Application Reference: 2026/0456

Site Address: 24 Charles Street, Barnsley, S70 1RB

Proposal: Remove existing conservatory and erection of single storey side extension to dwellinghouse.

SIDE ELEVATION - 1/100 @ A4

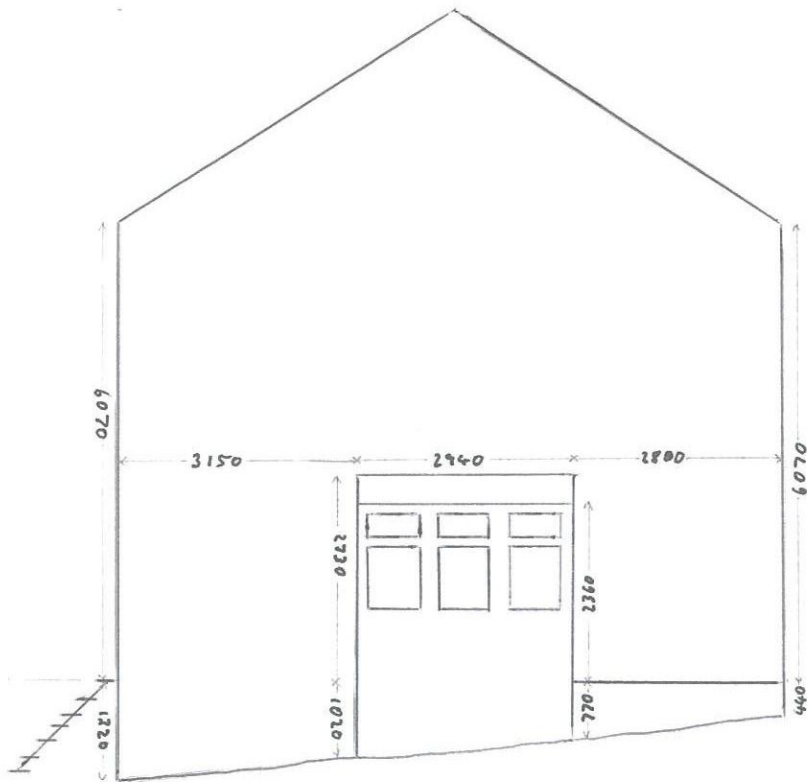
Glazing is proposed to the rear elevation of the extension to service a bedroom; however, the proposed glazing is at single storey level and would provide no more opportunity for overlooking to the rear than the existing rear elevation glazing of the dwelling. The proposed

side elevation window to service a shower room shall be conditioned to be obscured glazing in order to protect the privacy of the applicant and of neighbours to the west.
